Ann Machado - 81 Brighton Ave. - Permit #2013-02572

From: Ann Machado
To: phillip.j.davis71@gmail.com
Date: 12/9/2013 8:12 AM
Subject: 81 Brighton Ave. - Permit #2013-02572

A2

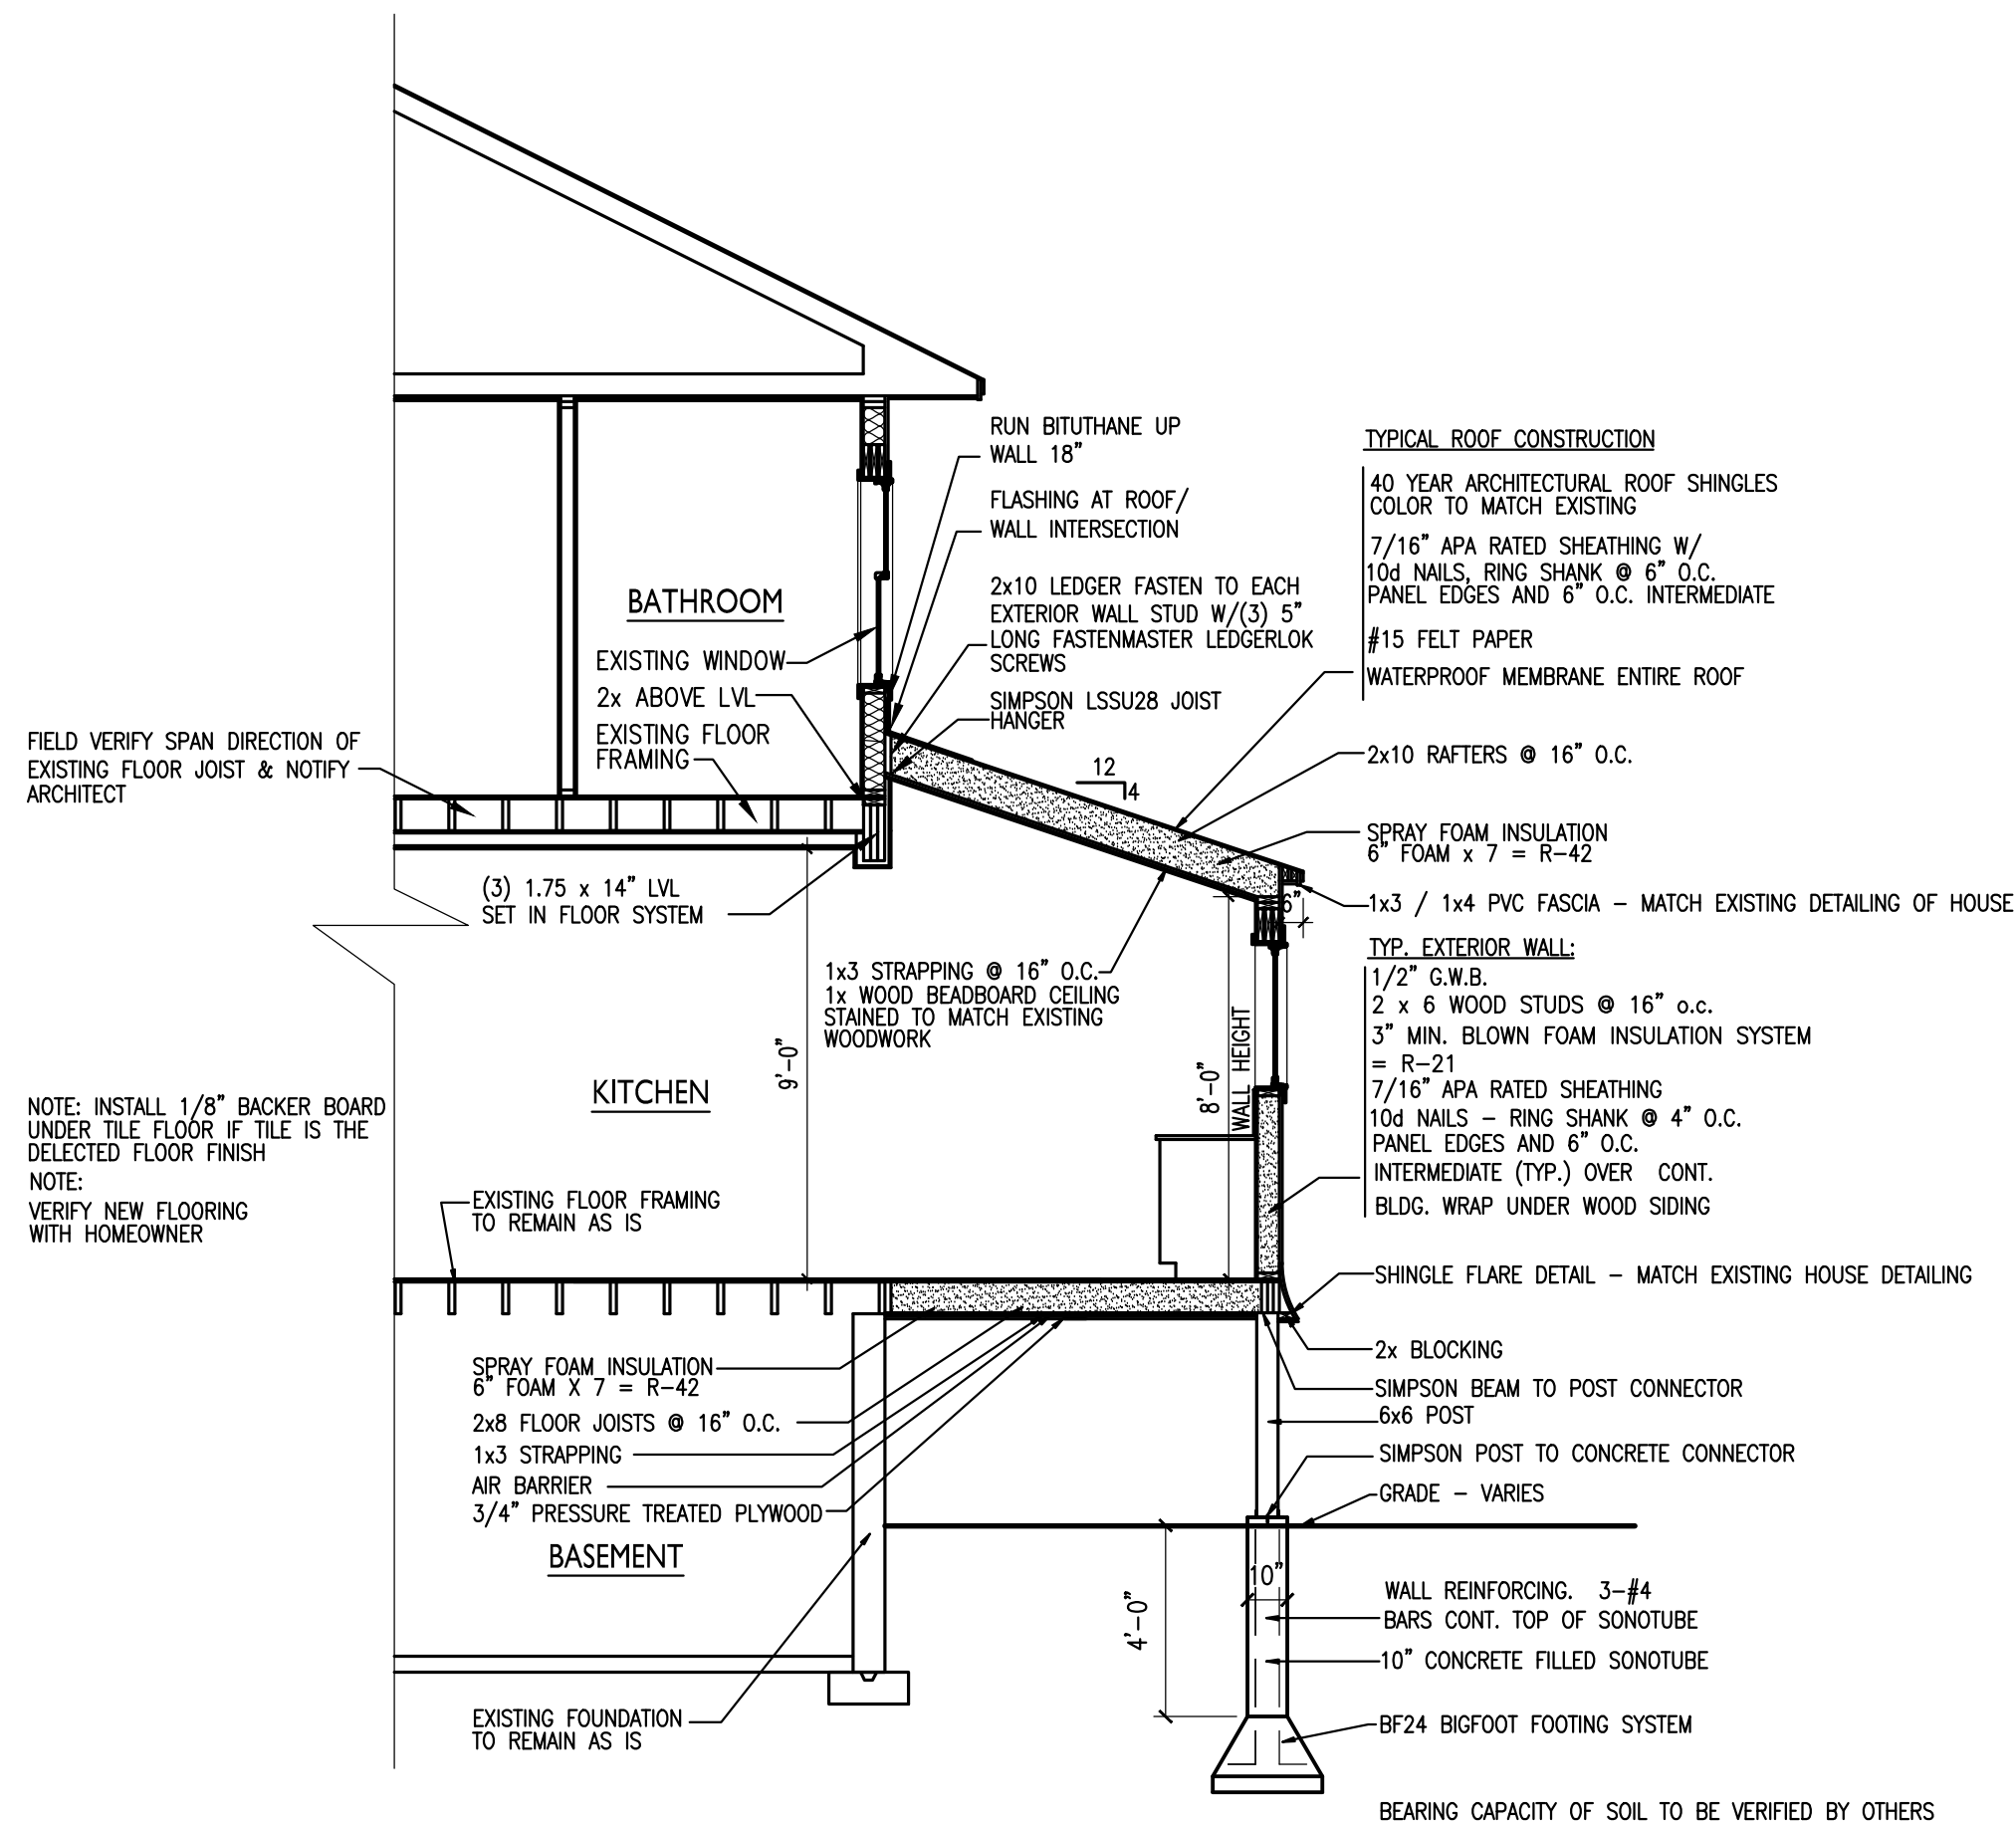
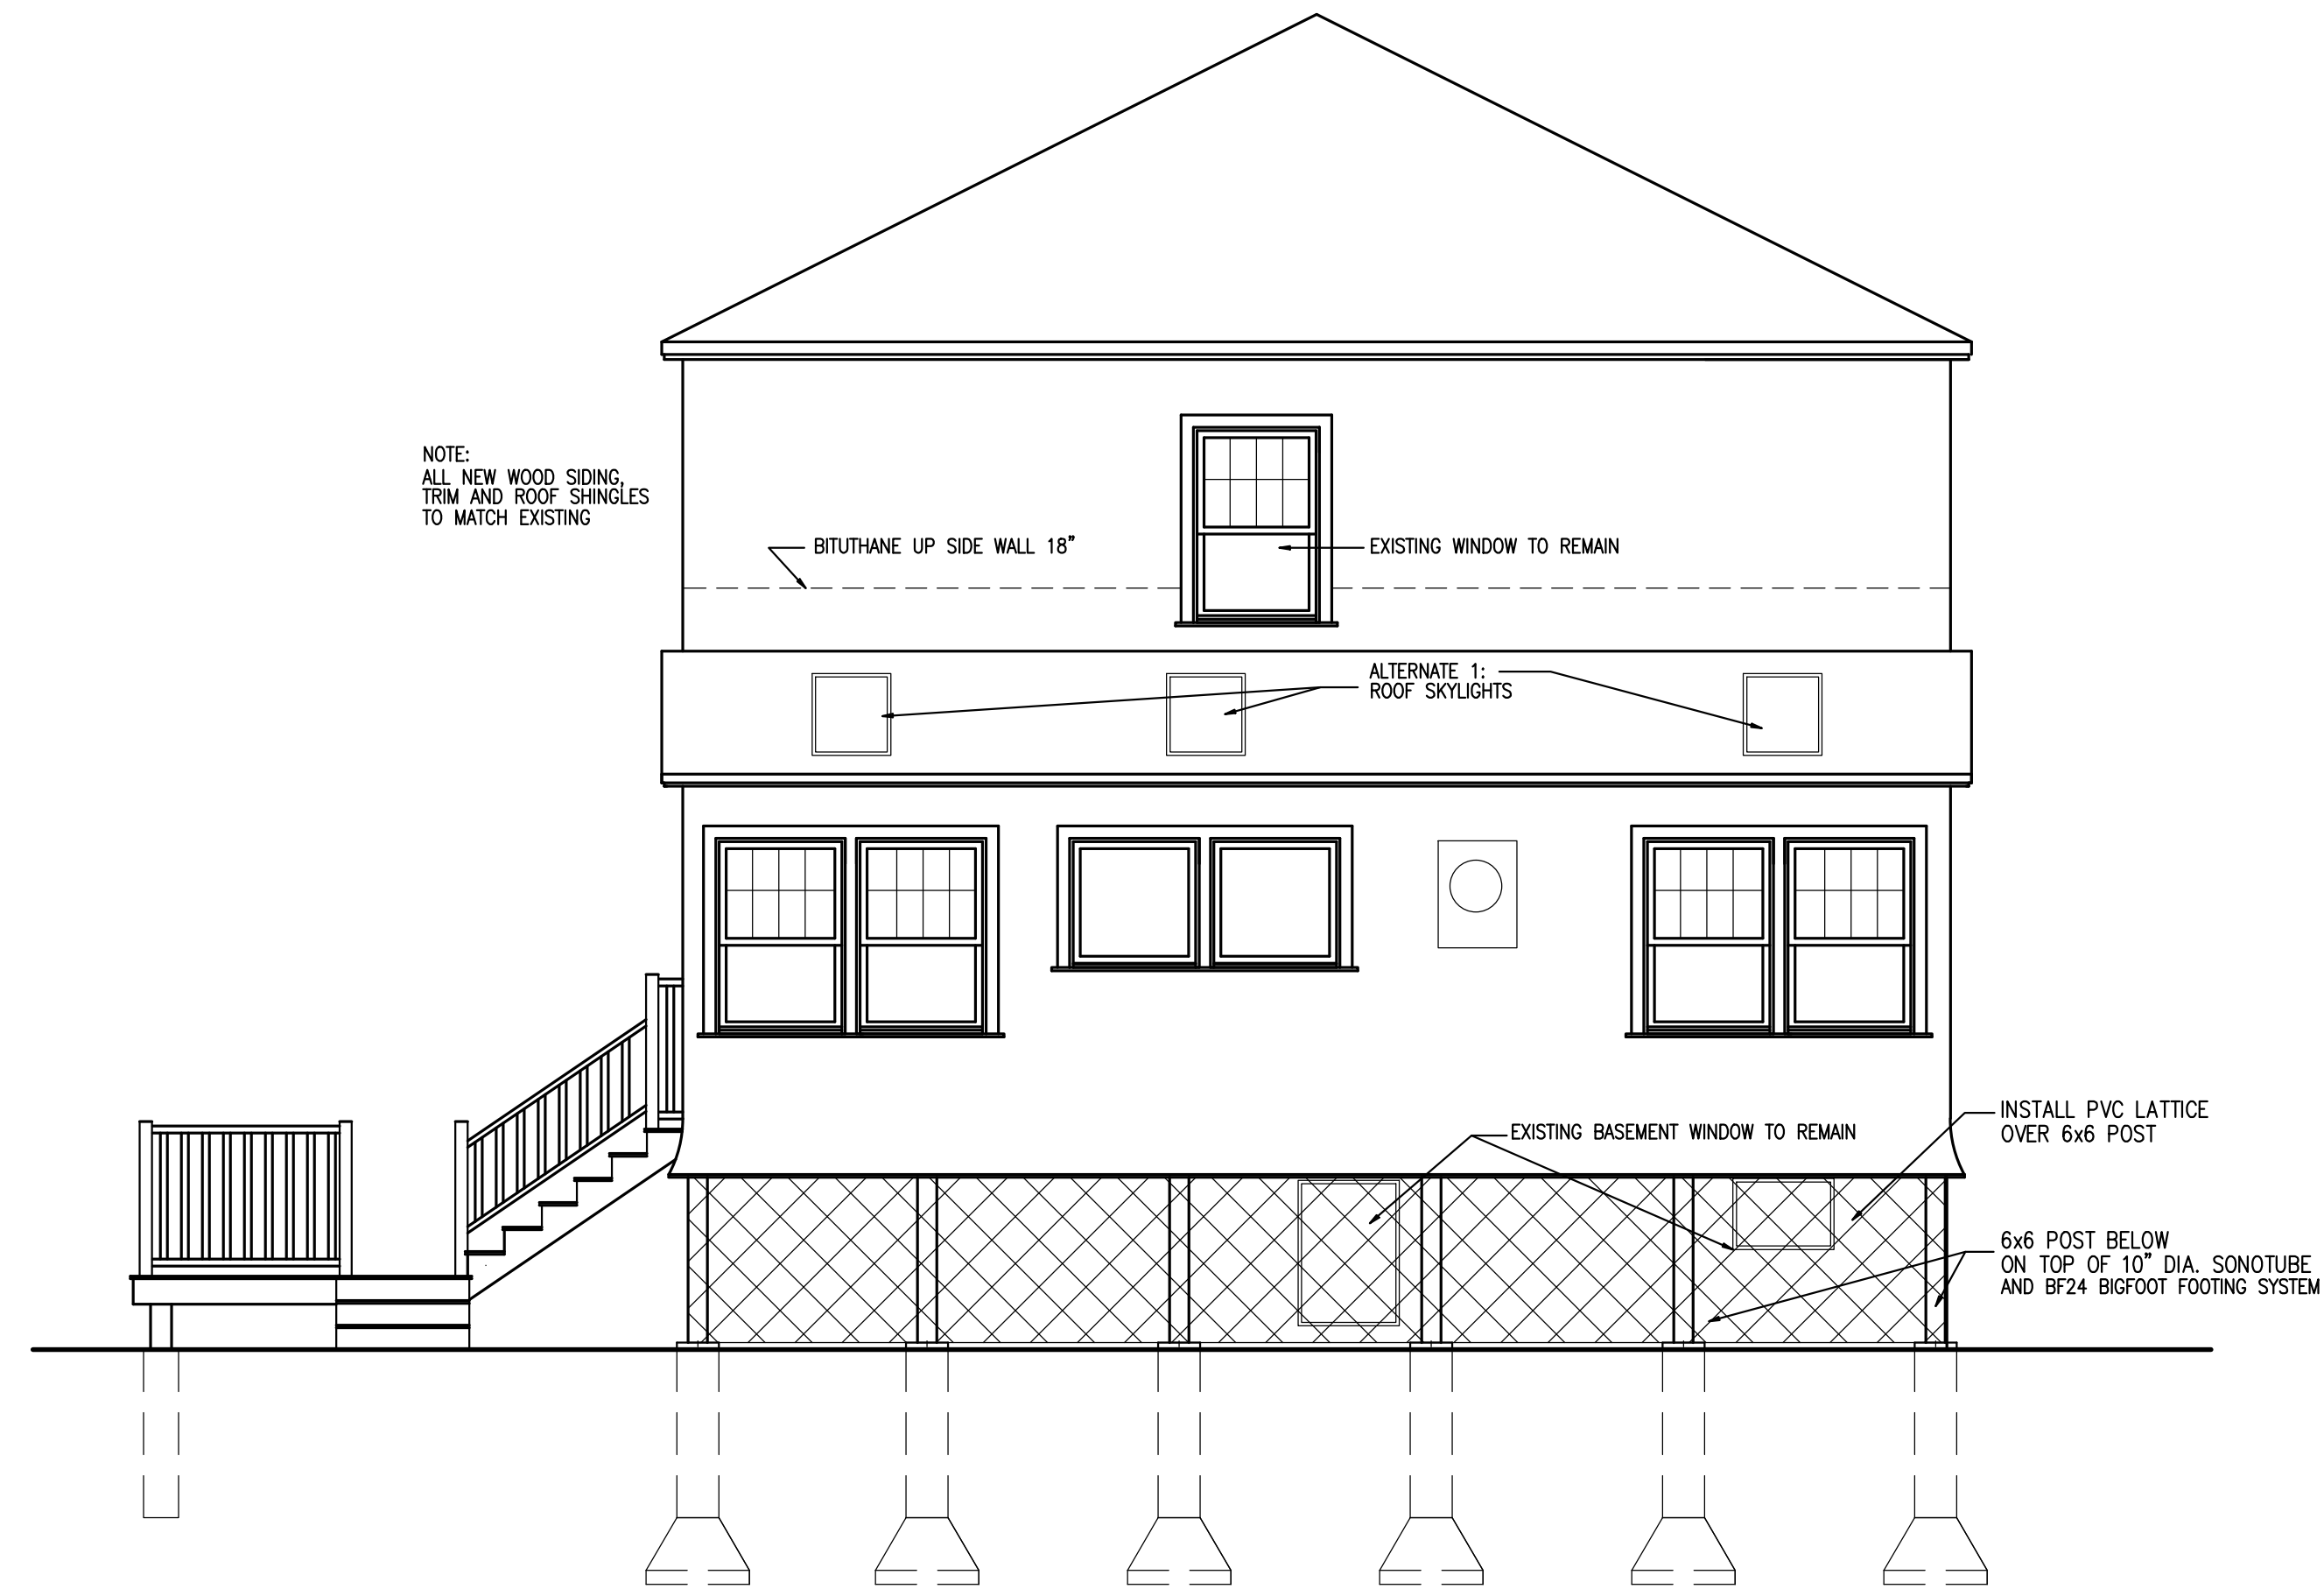
Also, now that we are doing electronic plan review, each plan needs to include a graphic or bar scale. We have to be able to calibrate our measuring tool when doing our review.
